Objection to Planning Application number 2021/90163 provided by Bear Leisure Limited of Sude Hill Mill, Sude Hill, New Mill HD9 7BL

This objection, and the submissions set out below, are provided by Bear Leisure Limited which is the freehold owner of Sude Hill Mill and the nearest neighbour of the premises the subject of the application.

TERRACE ELEVATIONS.

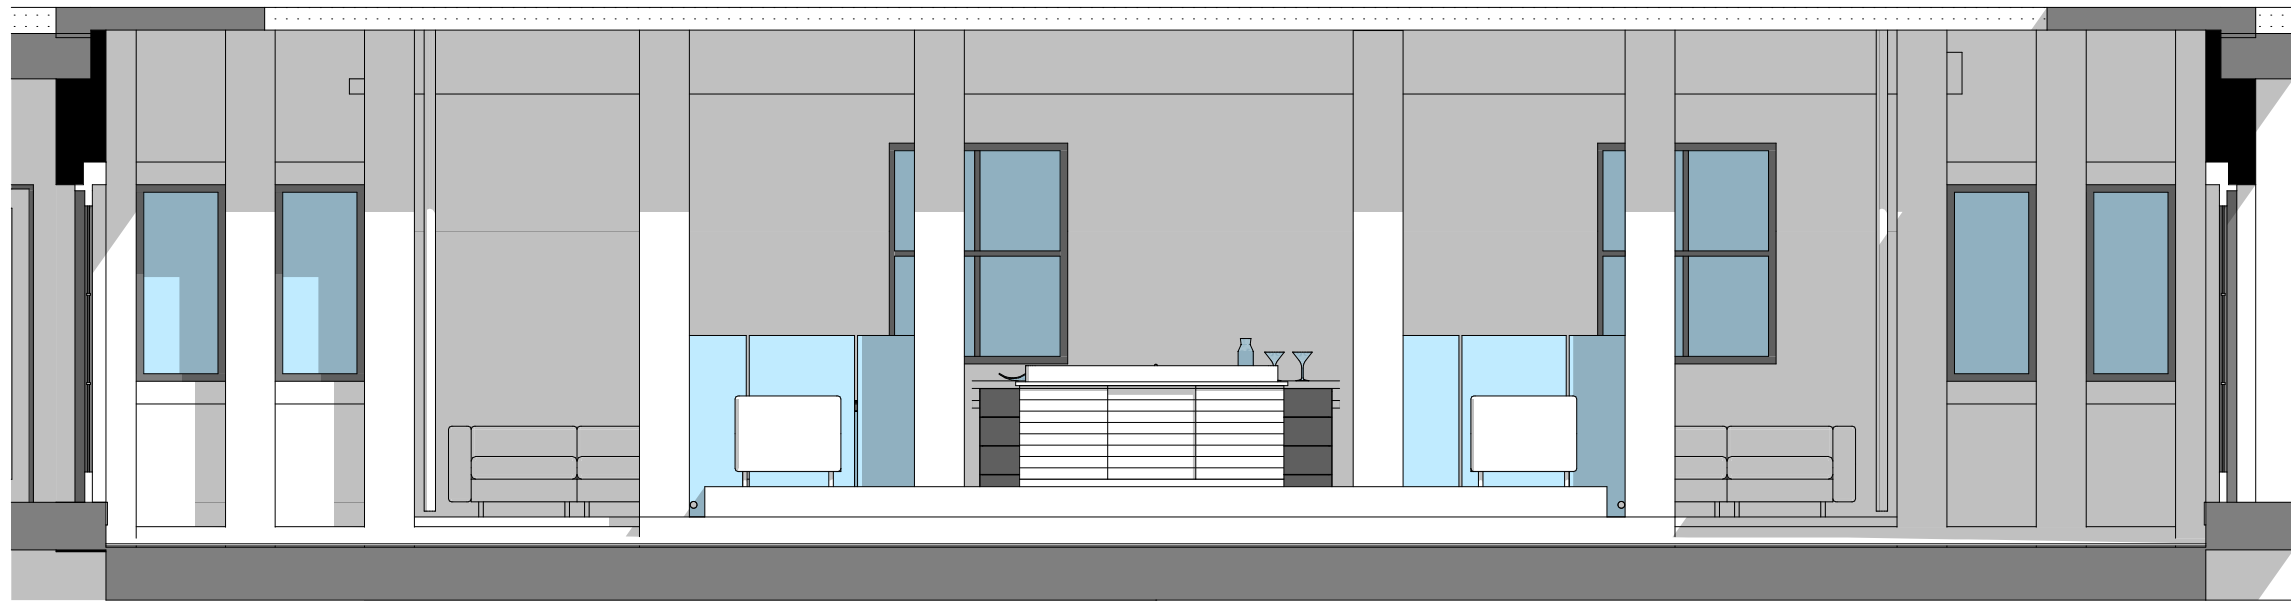
- In addition to the above, it is noted that the plans for the proposed development suggest that roof terraces/garden space will be created above ground level. The positioning of this terrace is unclear from the planning application – whilst showing to the eastern elevation, other drawings do not make clear whether this will extend beyond this elevation to the sides of the building. The concern for Bear Leisure here is that the terrace could have the effect of allowing users in the terrace/garden space to potentially be able to look into the windows of Sude Hill Mill and into commercially sensitive areas of a tenant's office spaces. Such is the short distance between the two buildings, the concern is that images on computer screens would be clearly visible and text on whiteboards would be capable of being easily read. This would be unacceptable;

- The concerns about the location of this proposed terrace/garden are, Bear Leisure, expects shared by the owners of properties directly opposite from the property which will be clearly overlooked by this terrace/garden;

- The points above in relation this proposed terrace/garden can clearly be added to by questioning the sense and safety of having this sort of feature directly above a major busy A road. Other garden or terrace spaces on Sude Hill have been set back from roads whereas this proposed terrace would look directly over the road. This creates a clear danger to pedestrians and vehicles;
